KITITAS COUNTY

MEMORANDUM

TO: All Staff
FROM: Public Works Planning Review Team
DATE: May 7, 2020
SUBJECT: BL-20-00013 Ponderosa Pines

**BOUNDARY LINE ADJUSTMENT BL-20-00013**

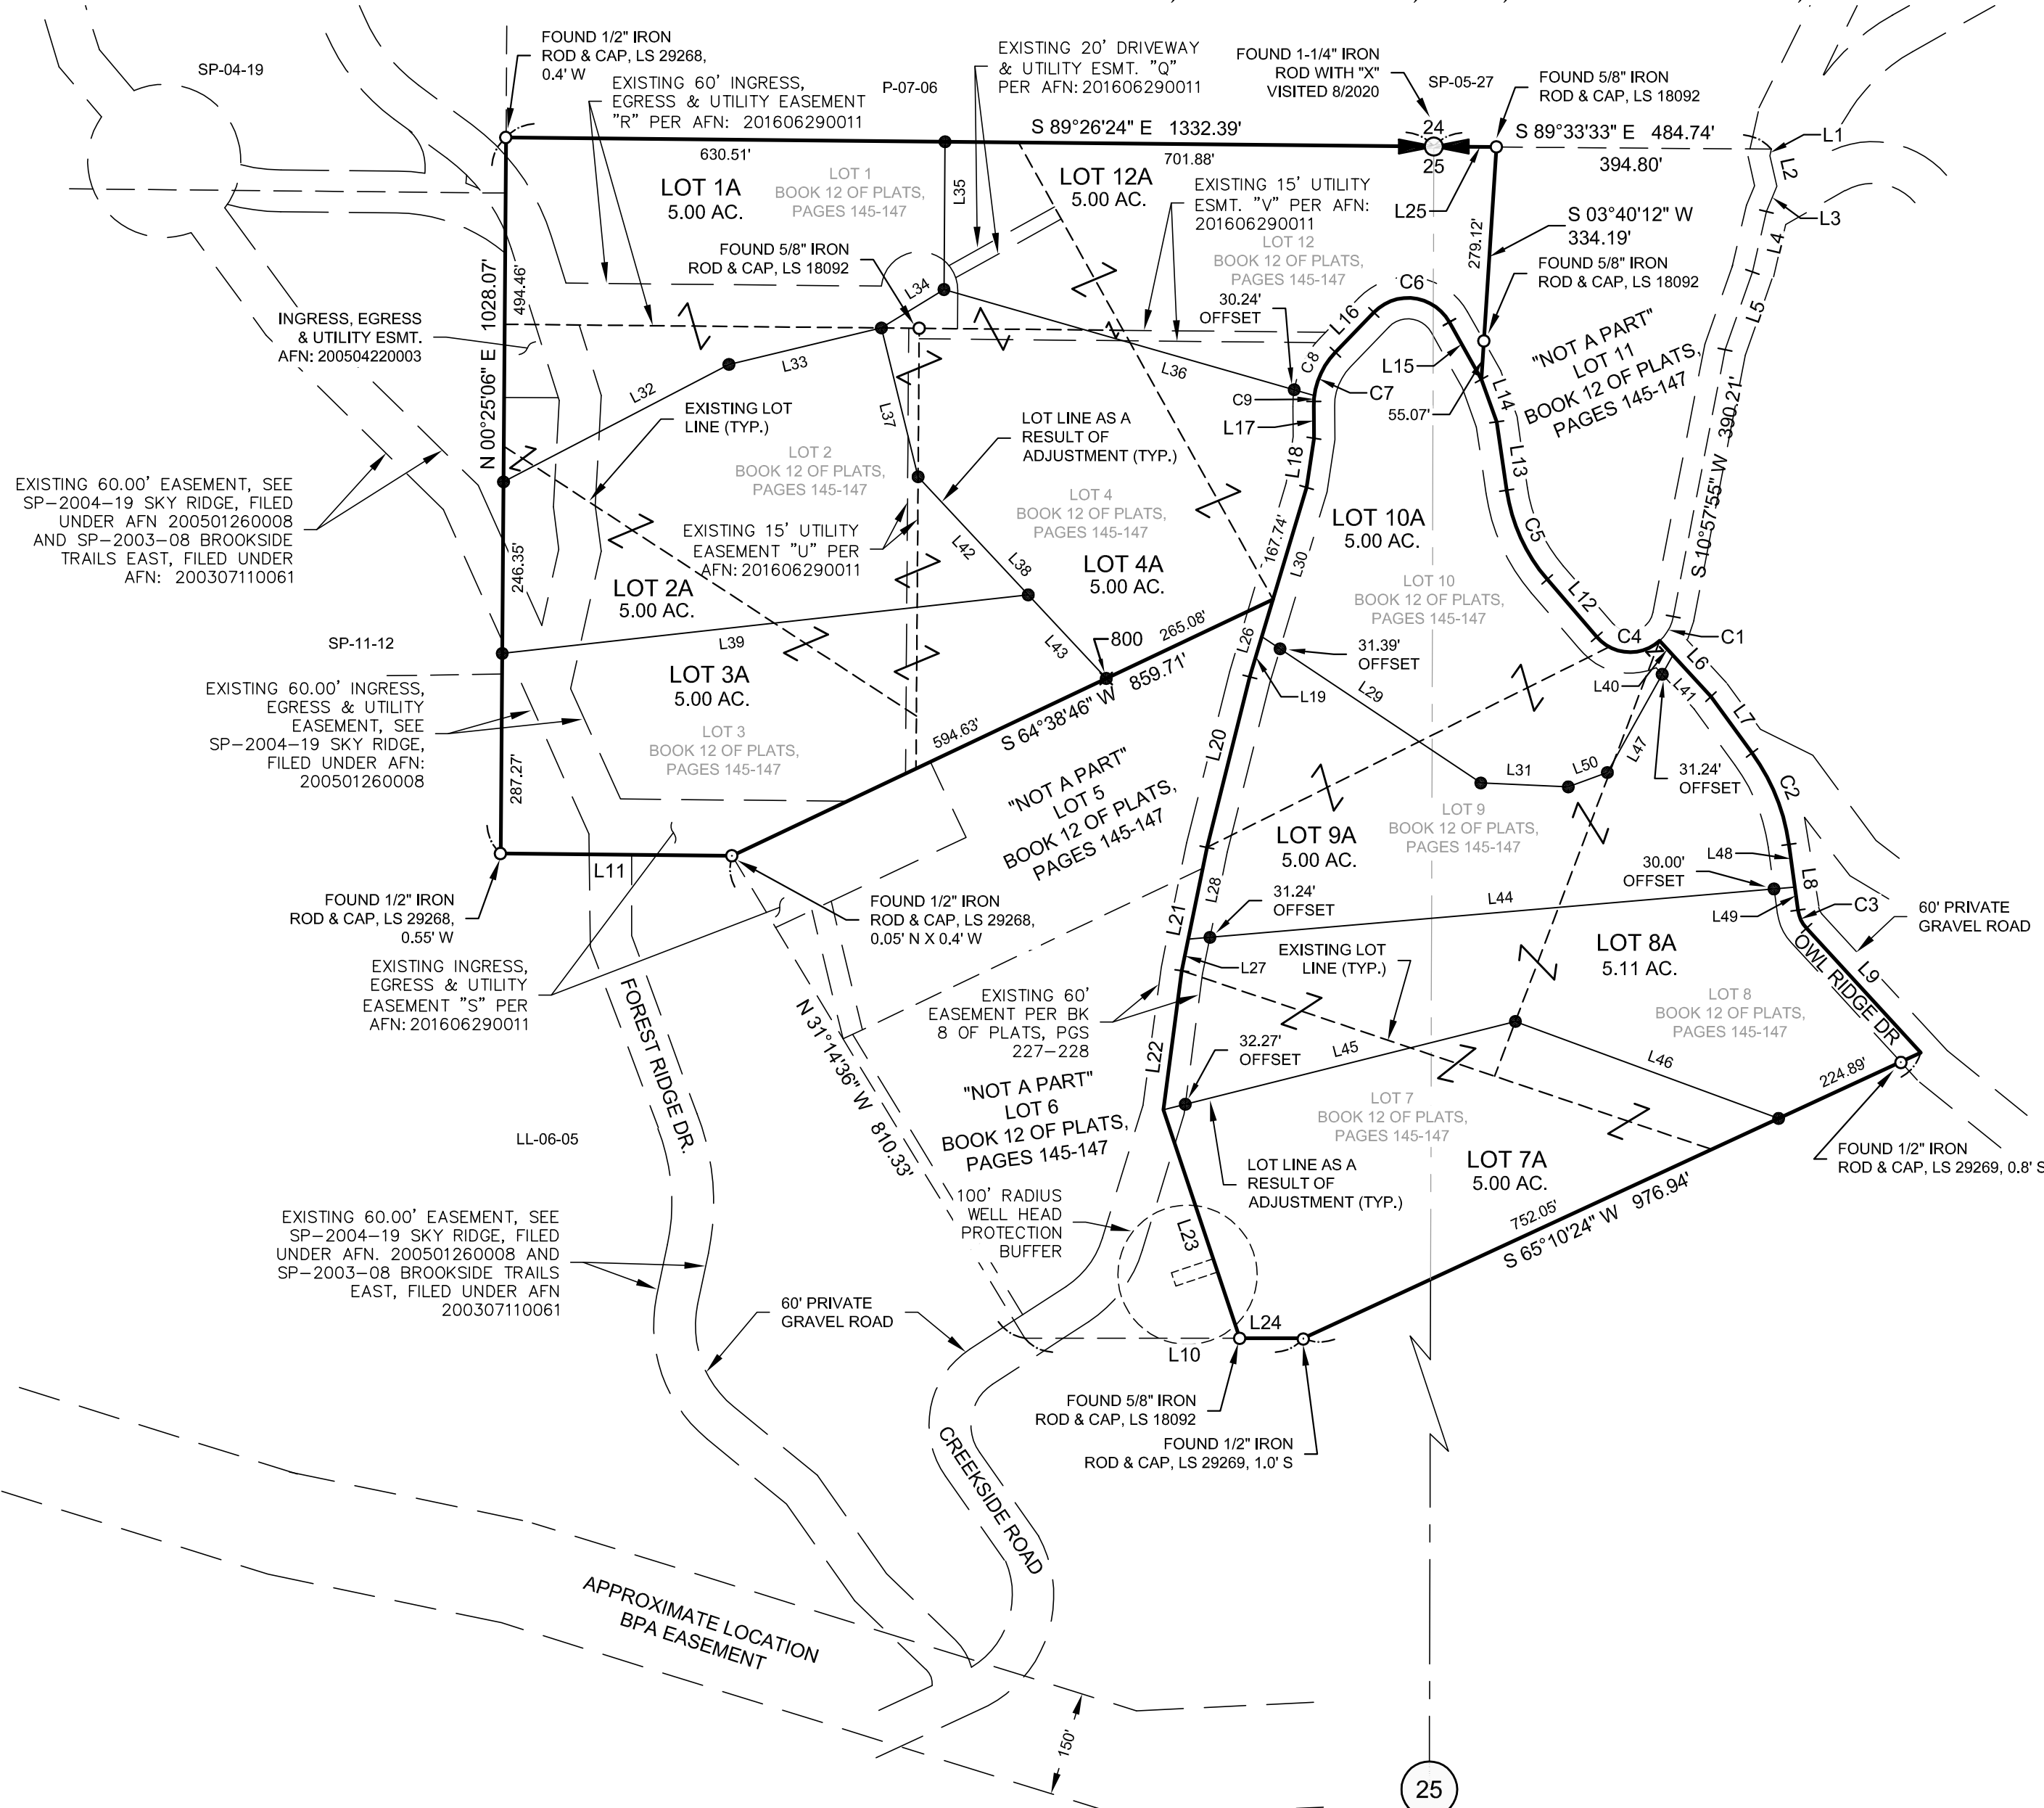
1. The BLA will need to include a surveyor's stamp, signature and statement.
2. The Equipment and Procedures statement is missing
3. The Auditors Certificate is missing.
4. The purpose of survey statement is missing
5. The basis of bearing is missing.
6. Section, Township and Range to be shown at top of page.
7. Road width/ownership and surfacing information should be included.
8. The BLA is missing a legend.
9. It may be preferable to show where the private roads connect to the county road system.

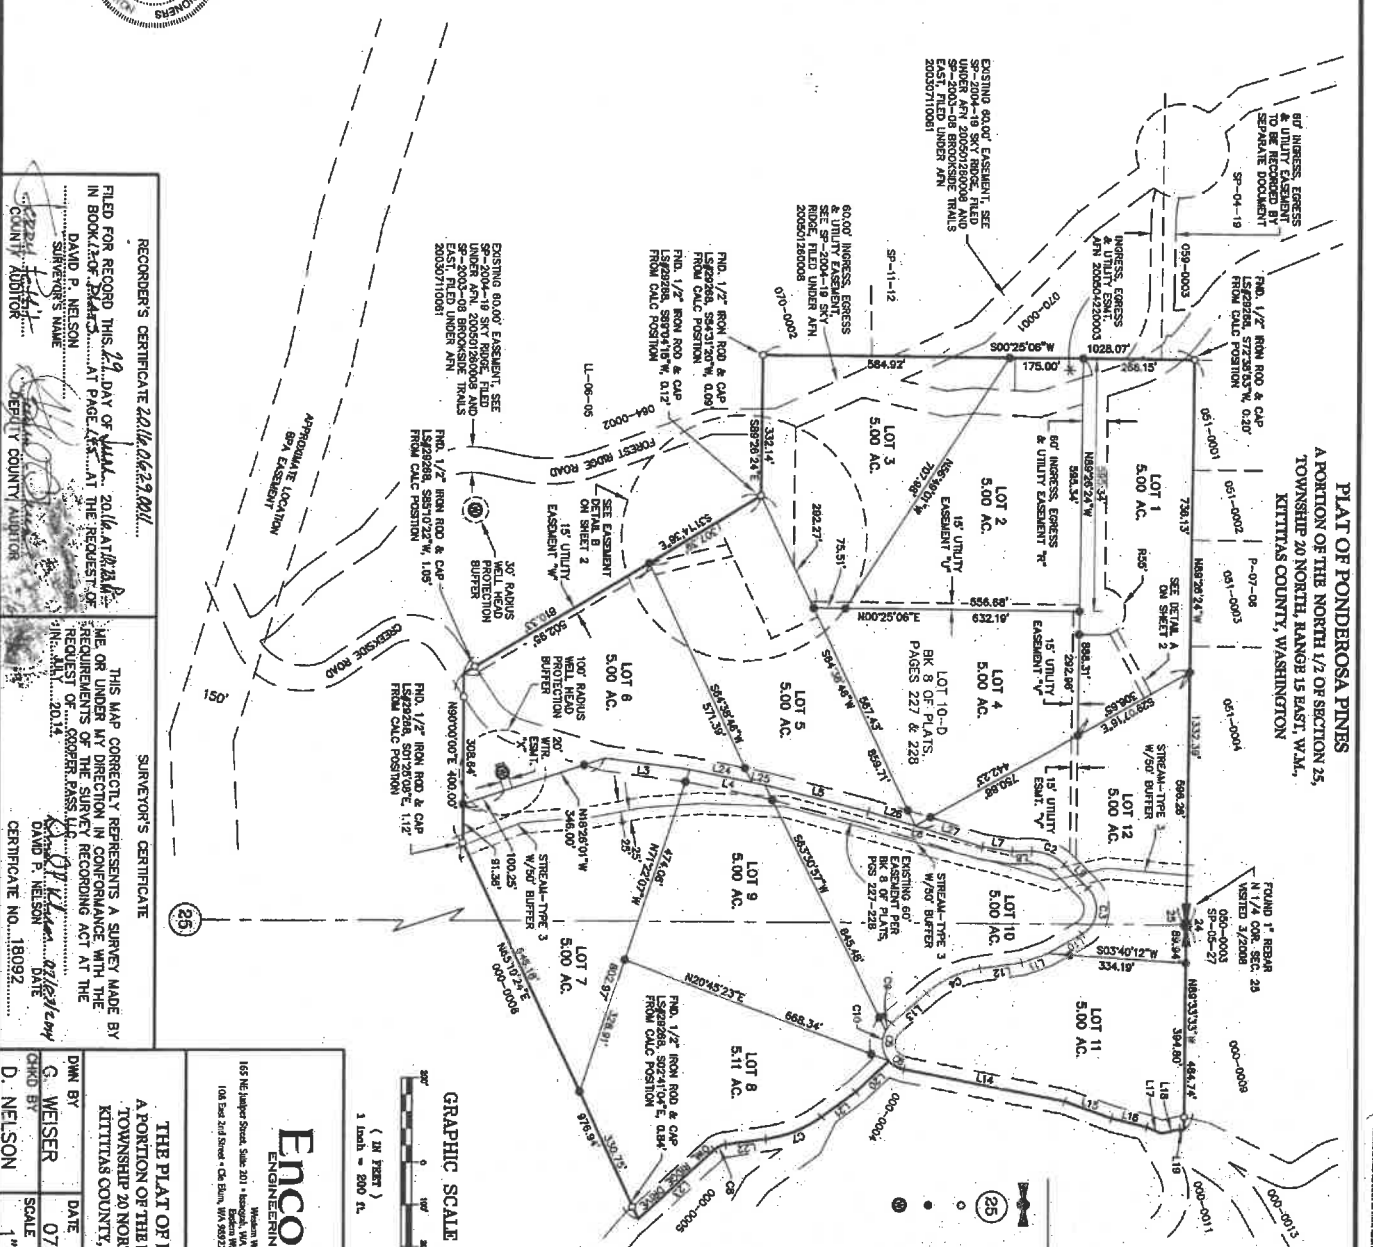
1. A revised legal description that describes the final configuration of the subject property shall be required.
2. A survey map for review.
3. Show access easements on the face of the BLA.
4. The proposed site plan does not provide access to every parcel in the BLA. Please provide access to every parcel within the BLA.
